RE: STATE SIGNIFICANT DEVELOPMENT APPLICATION (SSD 9522) FOR PROPOSED WAREHOUSE, LOGISTICS AND INDUSTRIAL FACILITIES HUB

PROPERTY AT: 657-769 MAMRE ROAD, KEMPS CREEK (LOT 34 DP 1118173, LOT X DP 421633, LOT 1 DP 1018318, LOT Y DP 421633 & LOT 22 DP 258414)

Table 1: Response Matrix

01 LANDSCAPE SECTION A-A
Scale 1:200@A3

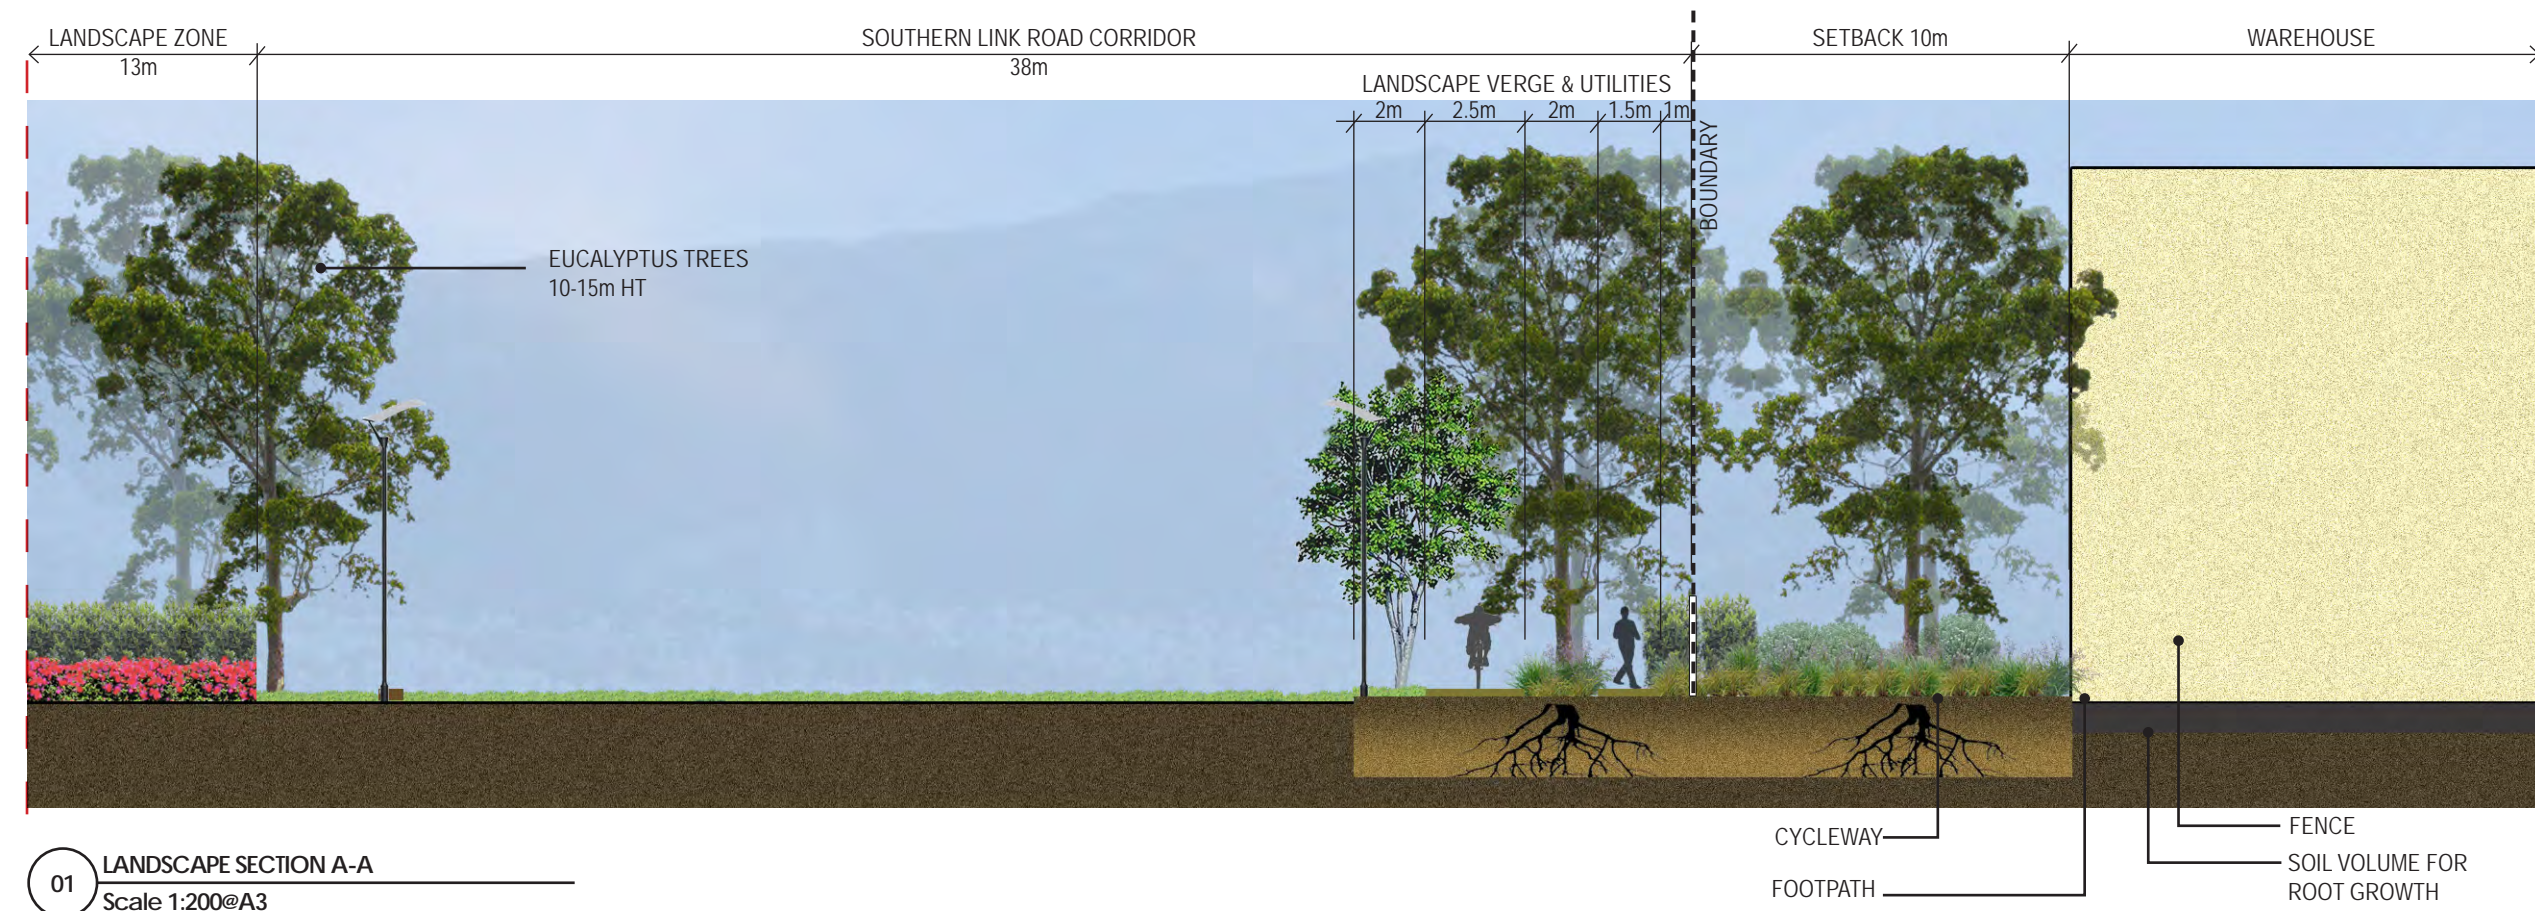
7.	<p><i>It is requested the fence line in the Landscape Plan Section C-C (Appendix 10) be set back into the site, rather than locating it against the property line.</i></p>	<p>Habit8 drawing set in Appendix 7 of this Submission has been updated in Section C-C as requested.</p>

02 PROPOSED DISTRIBUTER ROAD - SECTION AA
SCALE - 1:200 @ A1

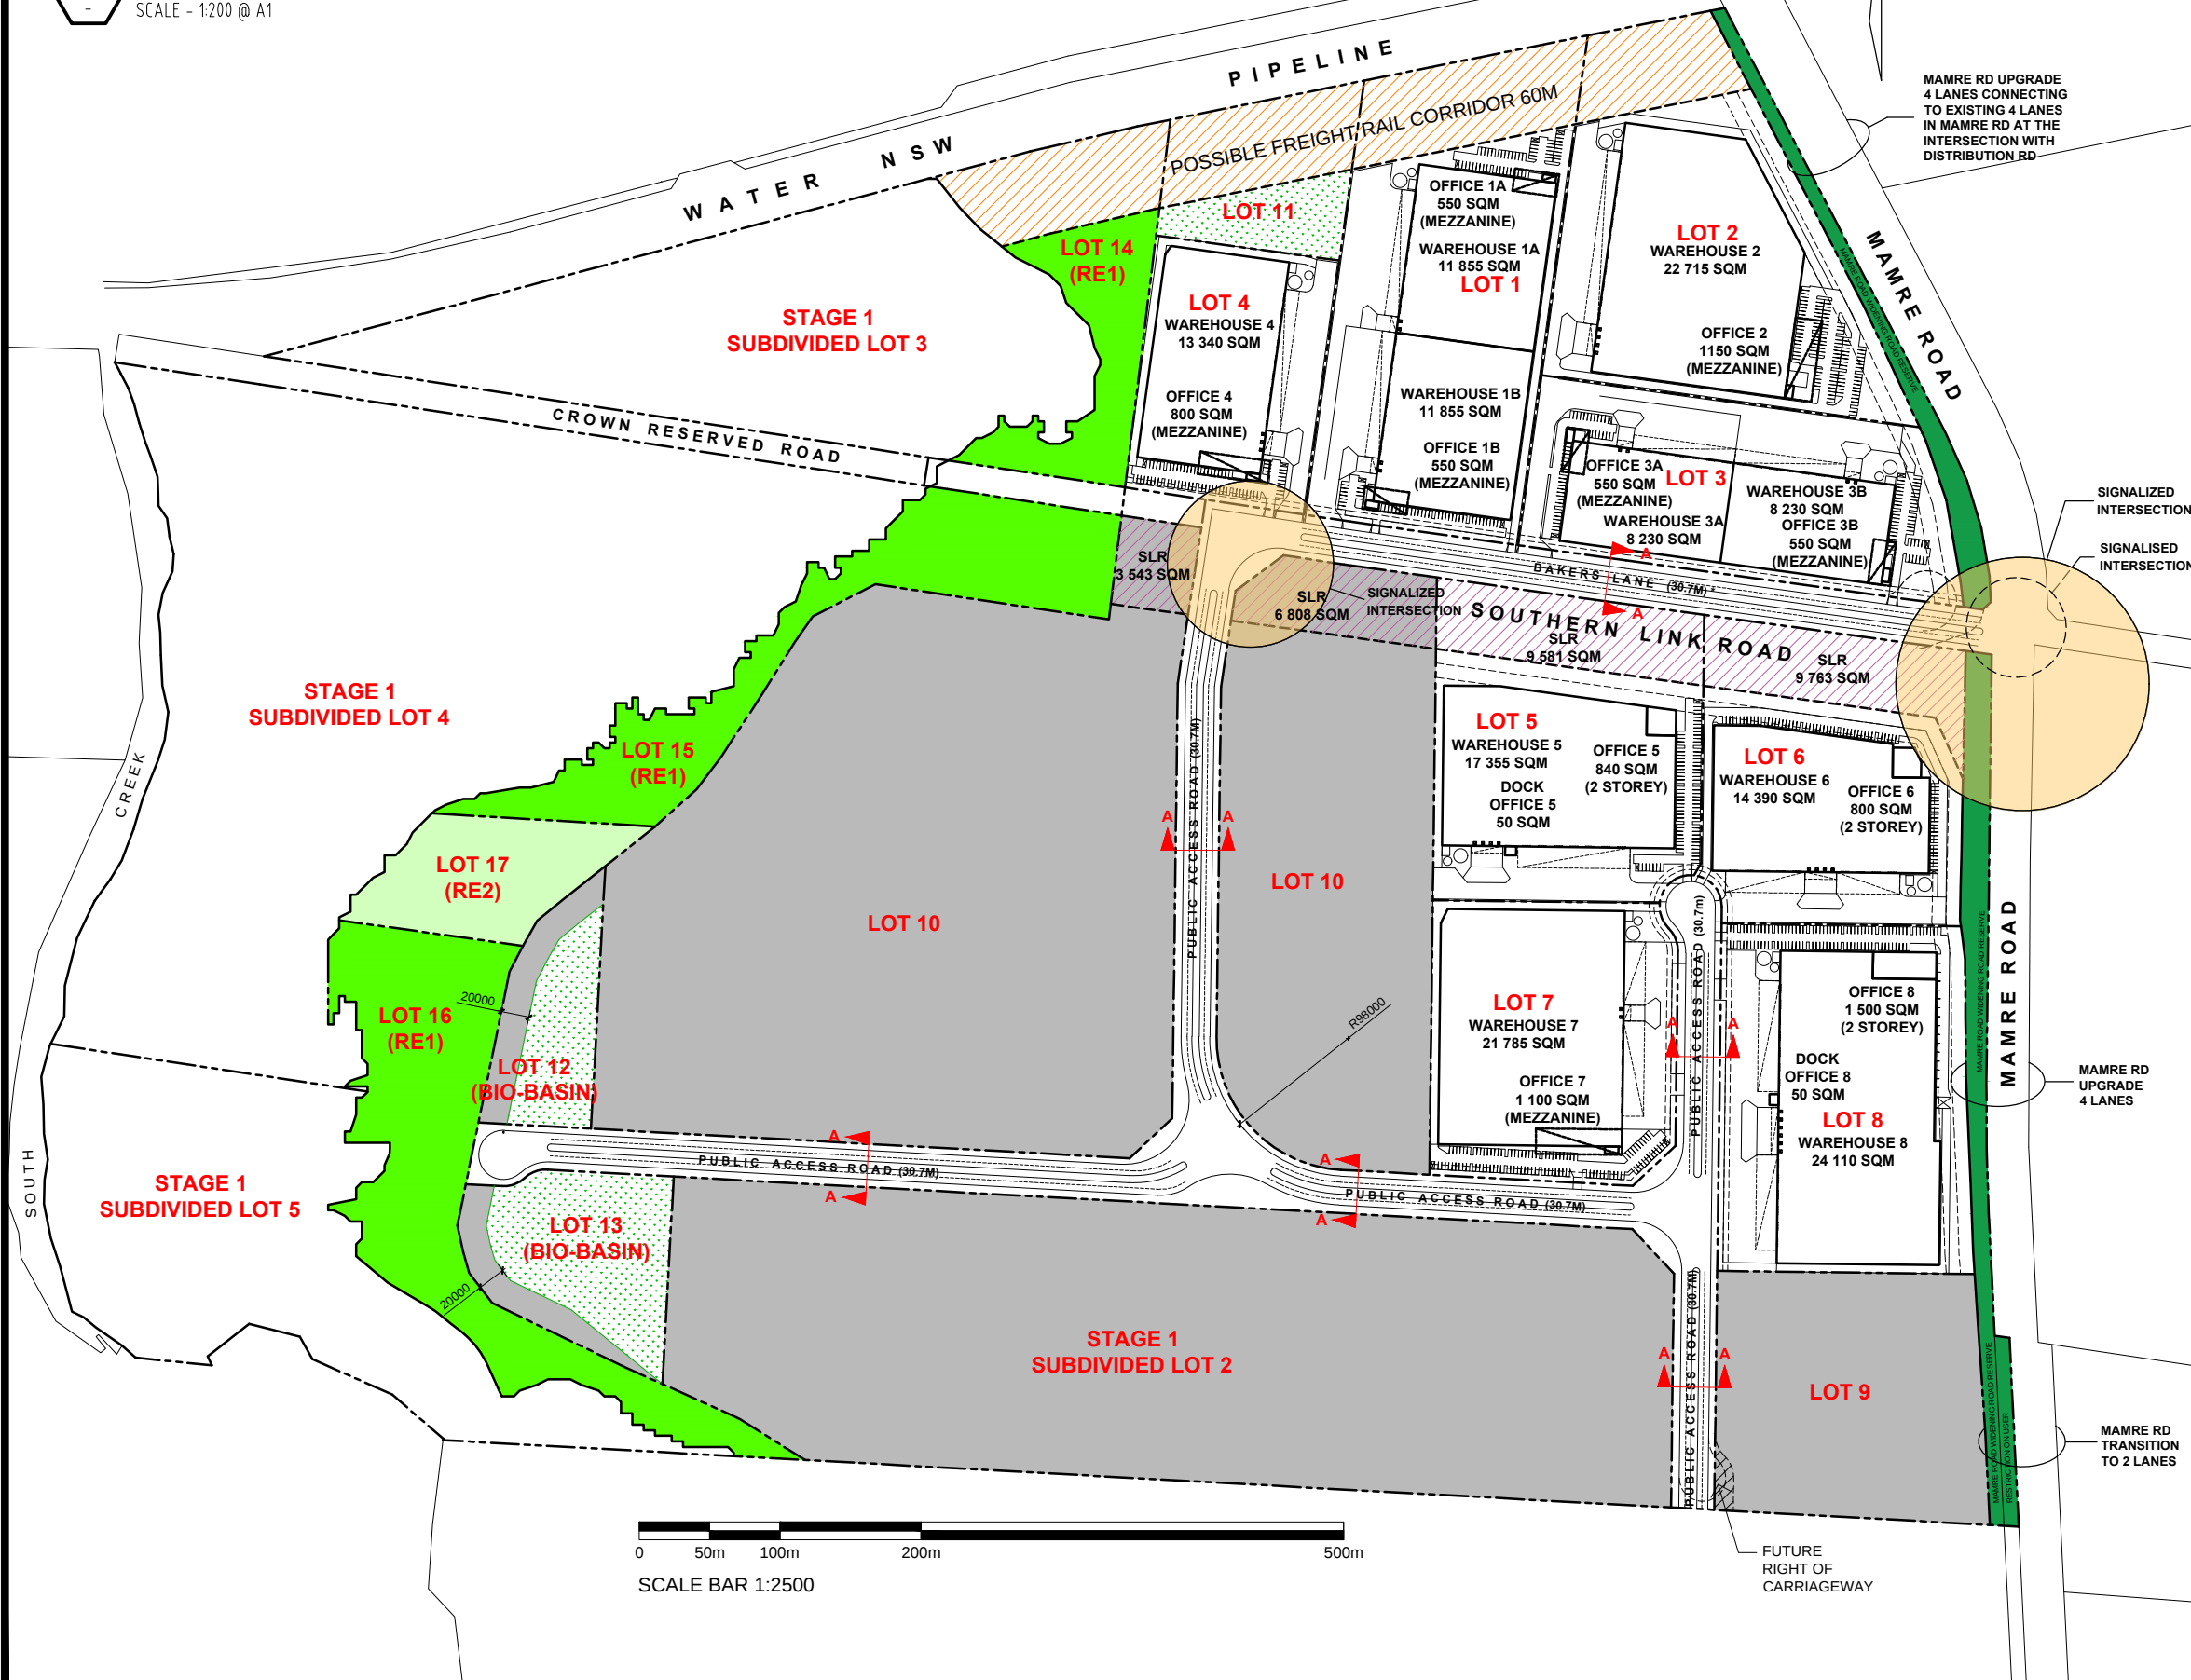
1.	<i>The north-south road must be designed to cater for a 30.7m road width as identified in the email to the Applicant dated 28 July 2020. A response from a suitably qualified traffic consultant should be provided identifying that the parameters set out in the email dated 28 July 2020 can be achieved on site to create a safe and efficient road design. The submitted traffic assessment does not appear to address each of the points raised in the email.</i>	<p>As the Precinct wide traffic modelling has not been completed, it is agreed to adopt 30.7 m road widths for the purposes of the approval, noting once the road widths are finalised following the Precinct wide traffic modelling a Section 4.55(1A) Modification Application could be undertaken.</p> <p>The Applicant's traffic engineer (Ason Group) has compiled a satisfactory response with respect to the parameters in the NSW DPIE email dated 28 July 2020 demonstrating a safe and efficient road design has been achieved and can be conditioned accordingly. Reference should be made to Appendix 1 of this Submission.</p> <p>Revised plans for approval include the Masterplan, Subdivision Plans and associated swept paths (refer to Appendix 2-5 of this Submission).</p>
